CITY OF ALBUQUERQUE

November 16, 2018

RE: **Sunset Gardens Apartments**
86th and Sunset Gardens SW
Grading Plan Stamp Date: 11/1/18
Drainage Report Stamp Date: 11/12/18
Hydrology File: L10D032

Based on the submittal received on 11/13/18, the Grading Plan and Drainage Report cannot be approved until the following are corrected:

SECTION A-A
NTS

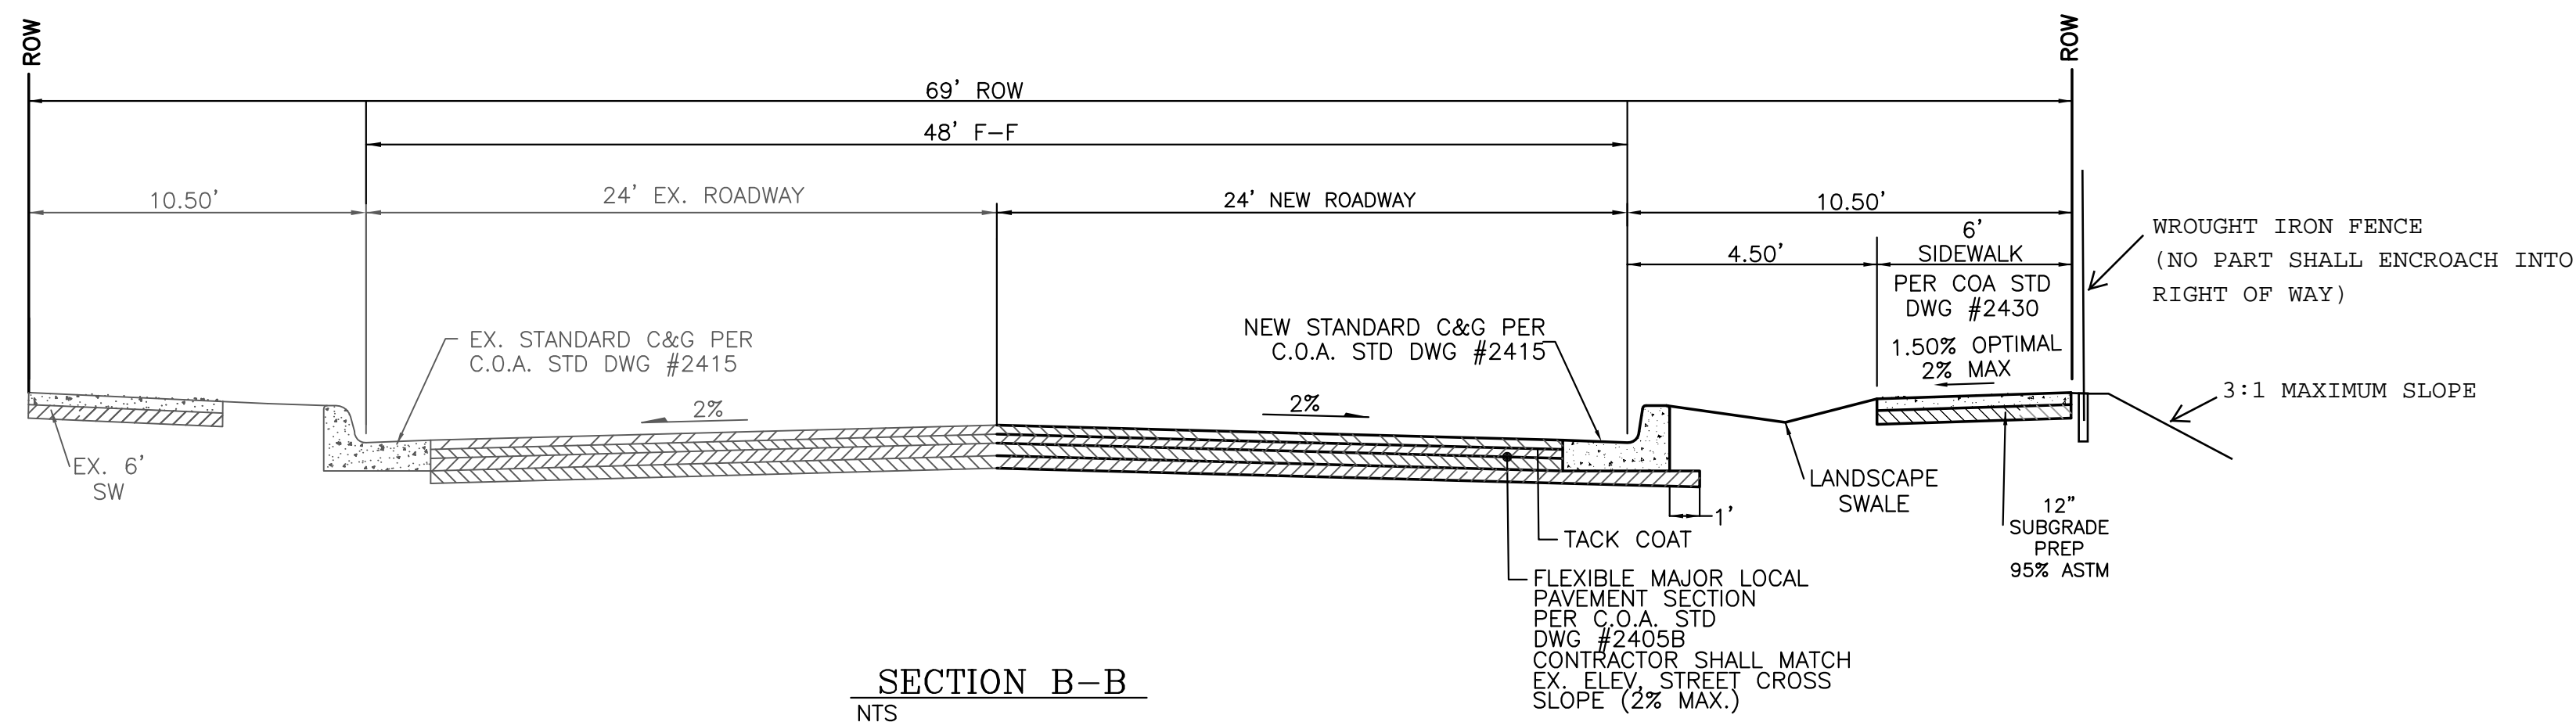
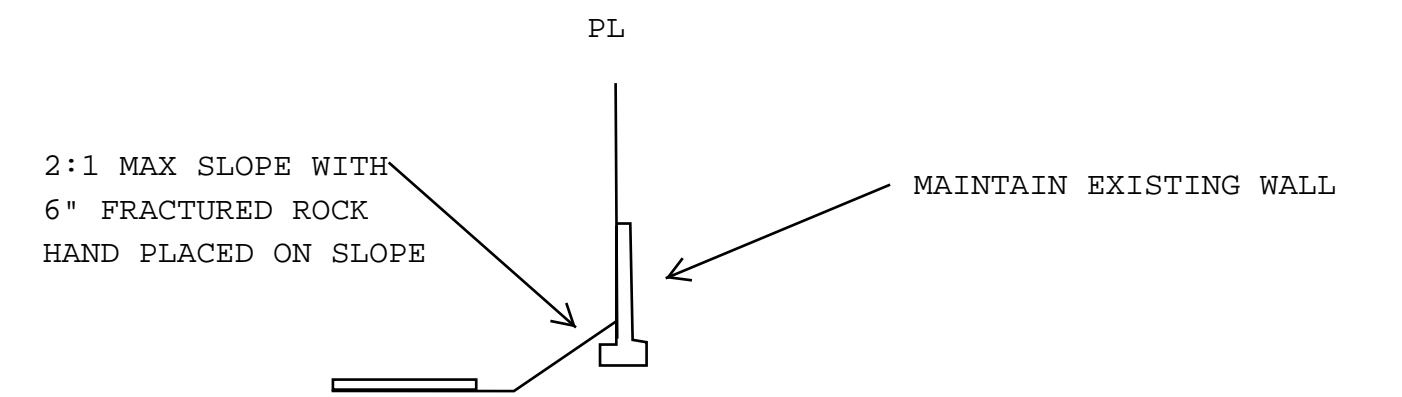
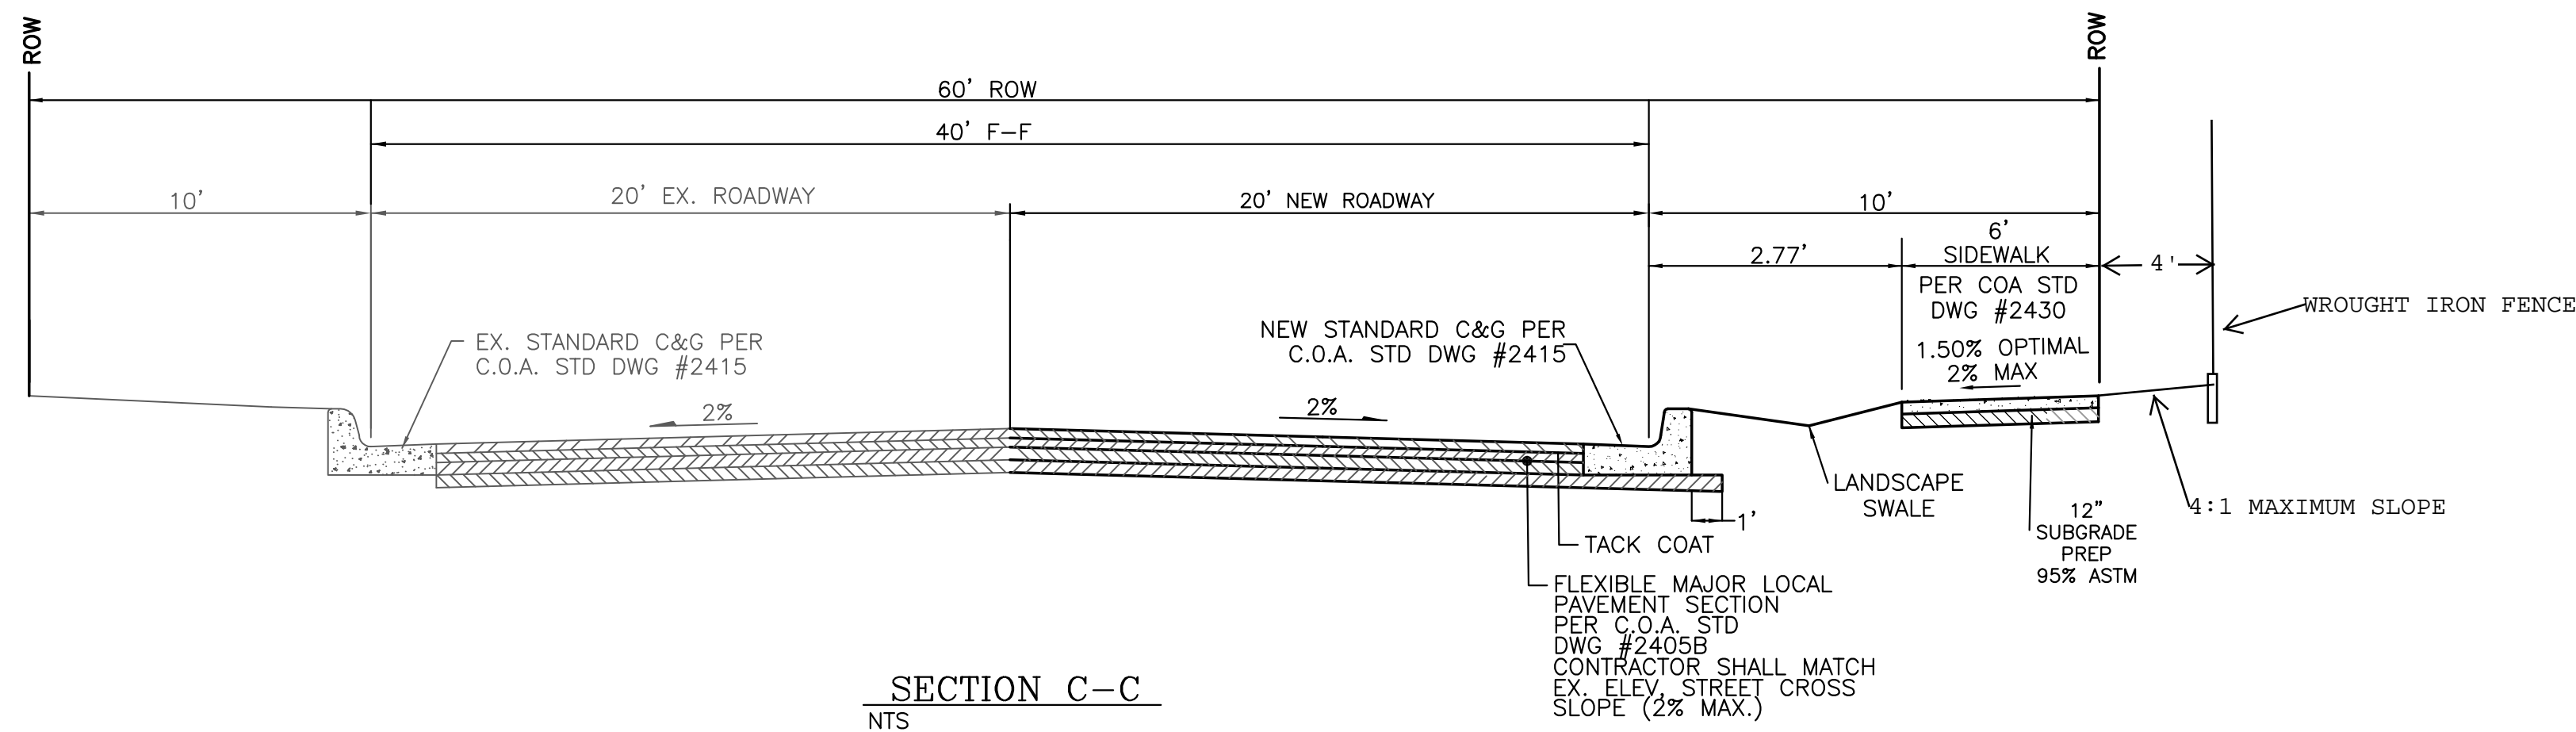
- b. Proposed Conditions. Basin E1 and E2 are captured by a Double-D inlet, not Double-A.
2. Provide cross sections, one for each road/property line and at the points of maximum retainage. Include retaining walls and footers, property/ROW lines, existing and proposed grades, horizontal and vertical dimensions, and proposed ROW improvements such as: sidewalk, curb and gutter, and paving. The section provided is insufficient.

3. For Hydrology, the cross sections must demonstrate that grading and wall construction near the property line will not endanger adjacent property or constrain its use (DPM Ch.22, section 5 part B). Any such encroachment by the retaining wall (including footer) or stable slope will be subject to the following:

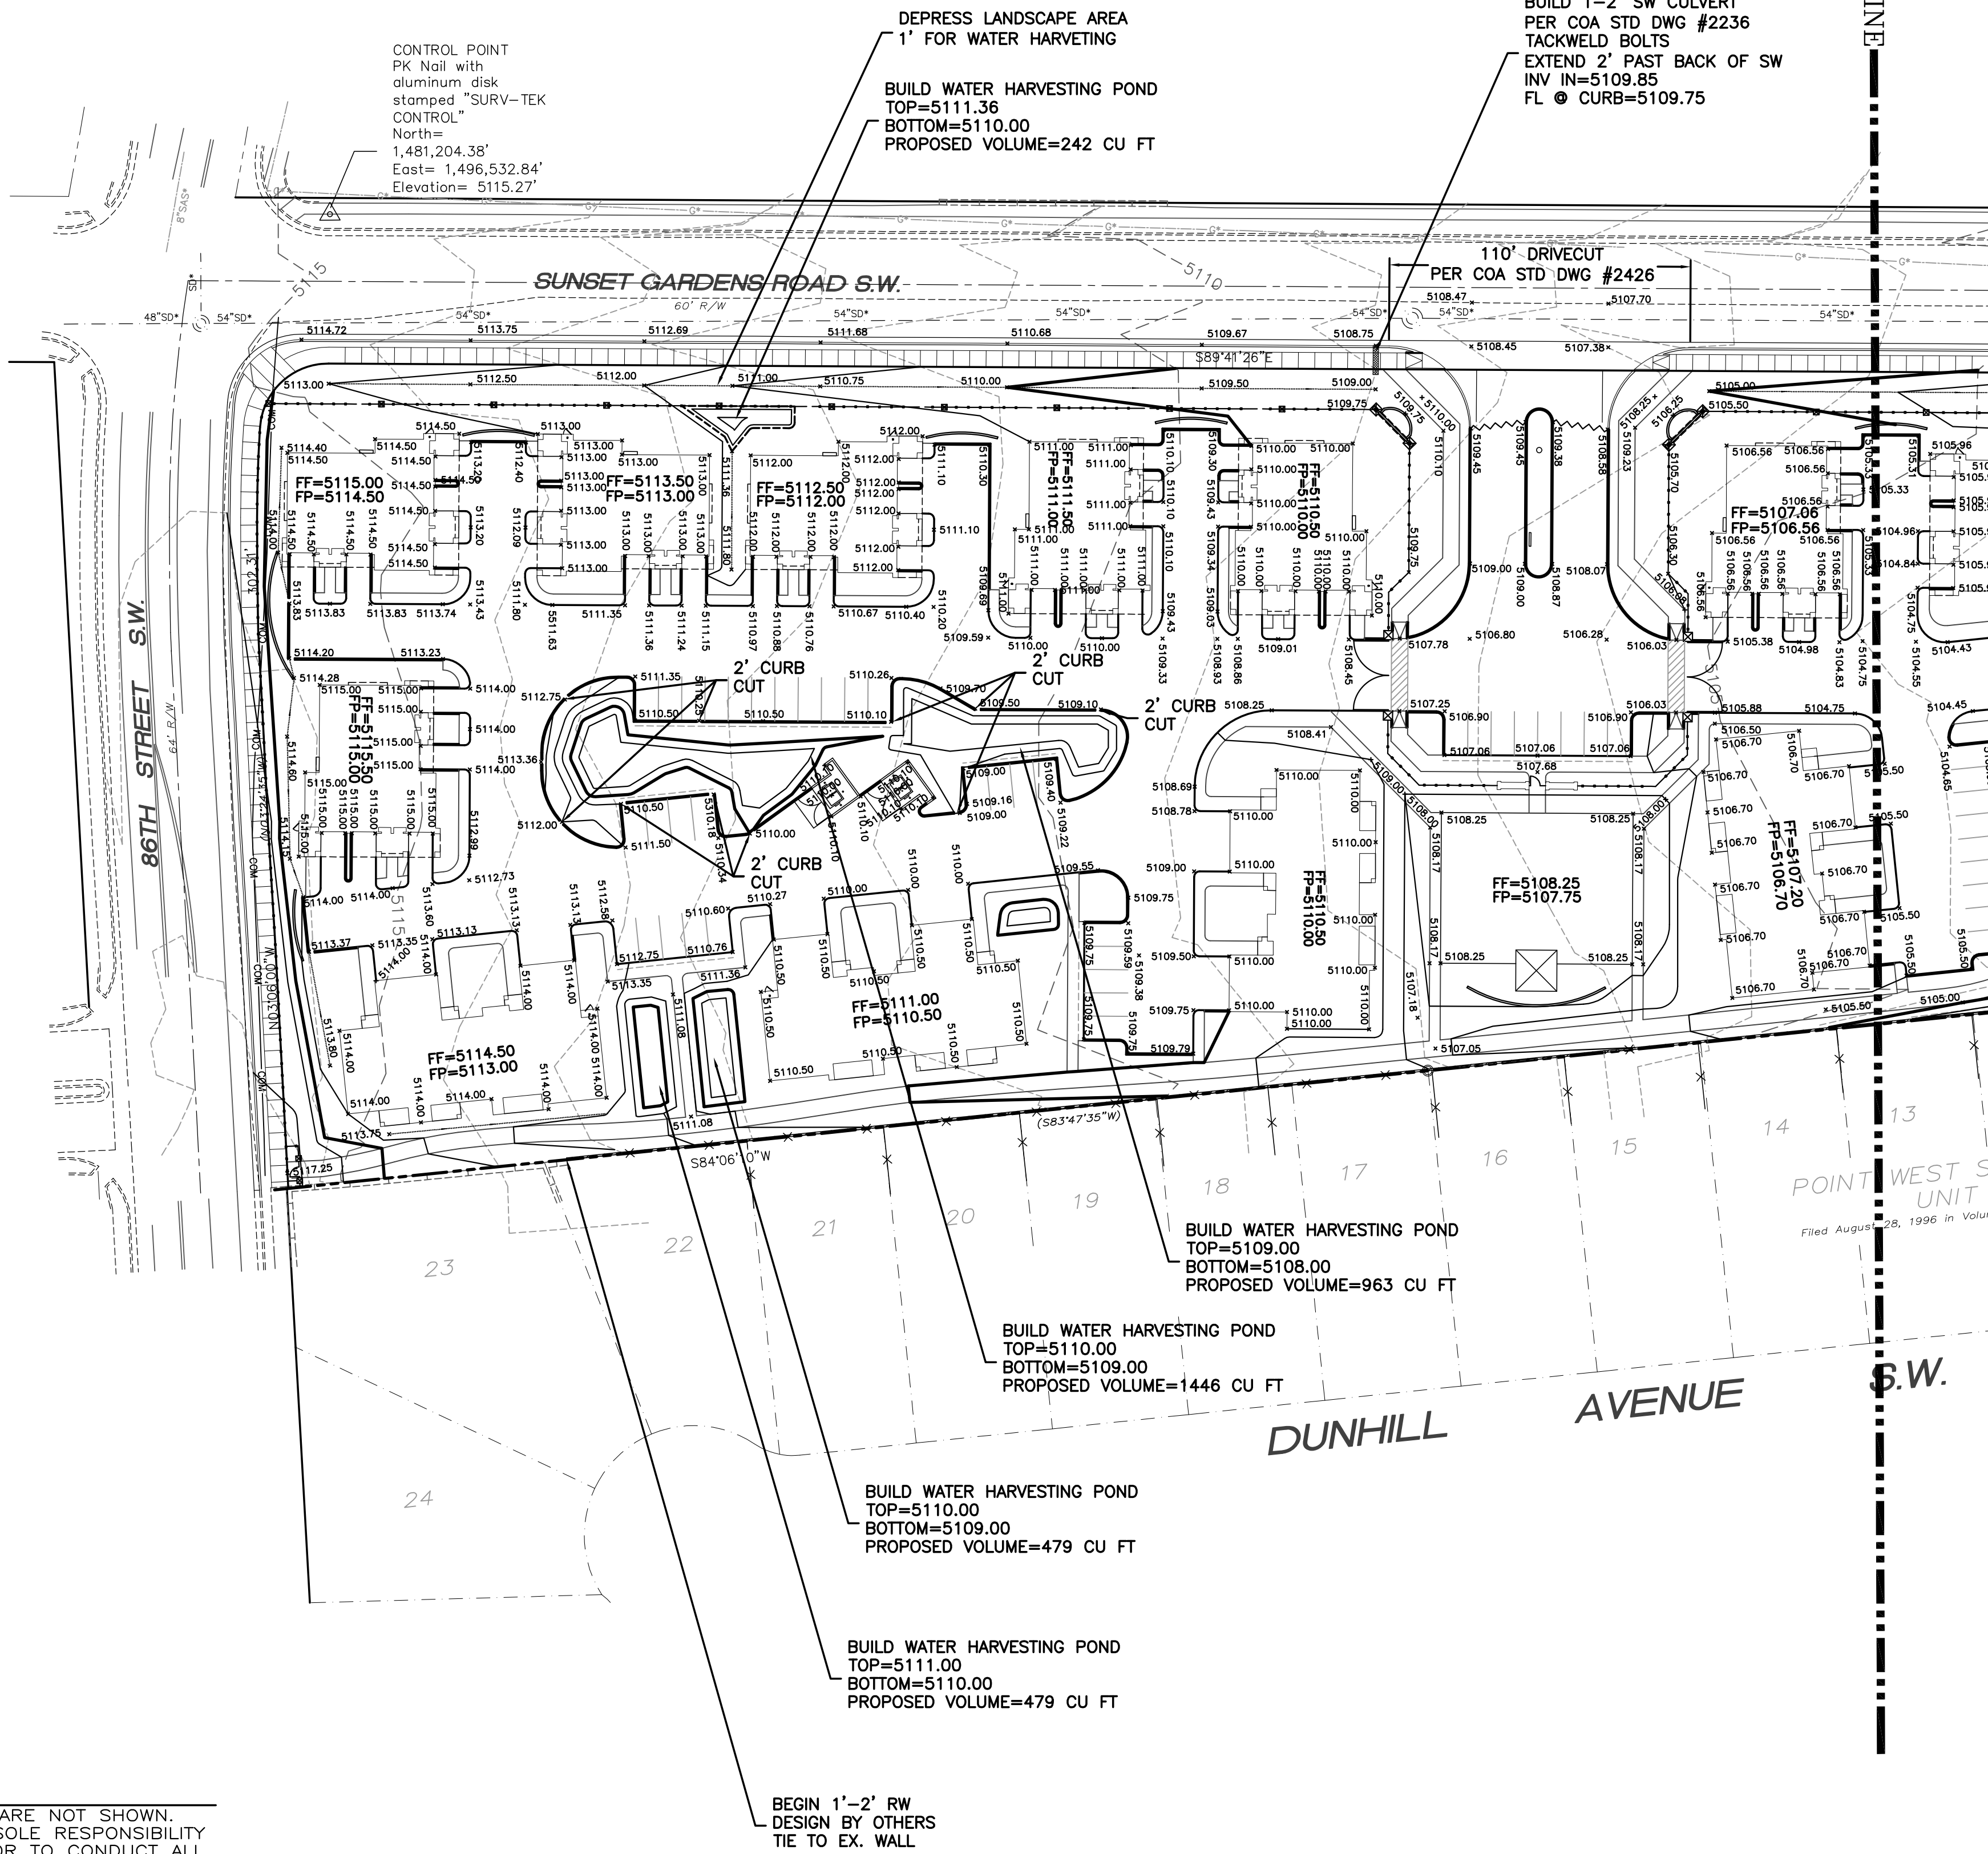
1. Correct the following errors and typos in the Drainage Report:
 - a. Purpose, Introduction, and Proposed Conditions. 82nd St is the correct boundary street, not 84th St. Get rid of any 84th St references.

7. Provide sumps around the nyloplast inlets (Basin A & C) to generate the head required in Appendix C (Hydraulics).
8. Pipe capacity and profiles for public and private storm drain, calculated along the EGL, will be required prior to building permit or work order, whichever comes first.
